17 February 2026

Patrick Copas
Department of Planning, Housing & Infrastructure
Locked Bag 5022
PARRAMATTA NSW 2124

Eastern Creek Data Centre Expansion Project (SSD-21342738-Mod-2) – Modification Application

Figure 1: Site plan (Ground level)

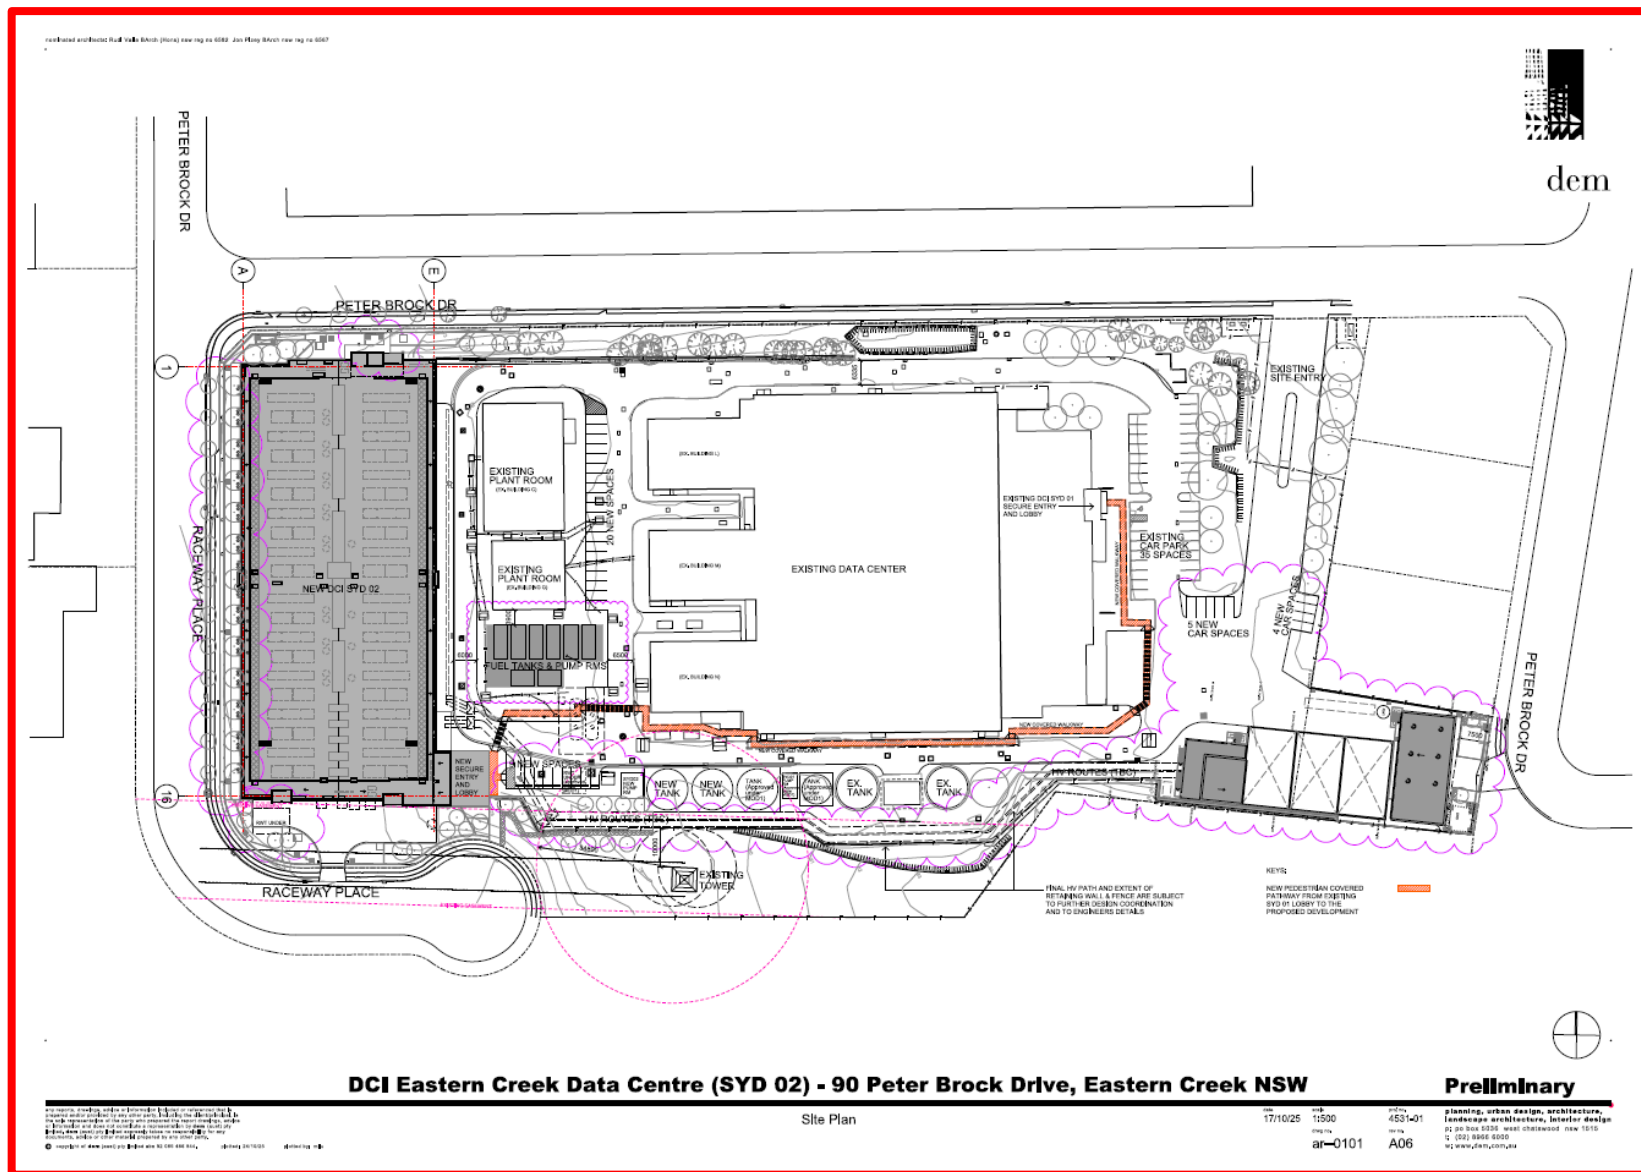
However, the proposal's overall footprint of the on-site substation has been expanded so that there is reduced setback from the boundary with Prospect Special Area and this increases the risk of the proposal activities encroaching into the Special Area. In order to ensure that all activities of the proposal including temporary, ancillary and permanent works remain within their lands at all times and not cross the boundary with the Prospect Special Area, WaterNSW requests amendments to the Modification Application 2 to increase the building setback between the substation and this boundary to a reasonable extent that enables all proposal activities to occur within the applicant's lands.
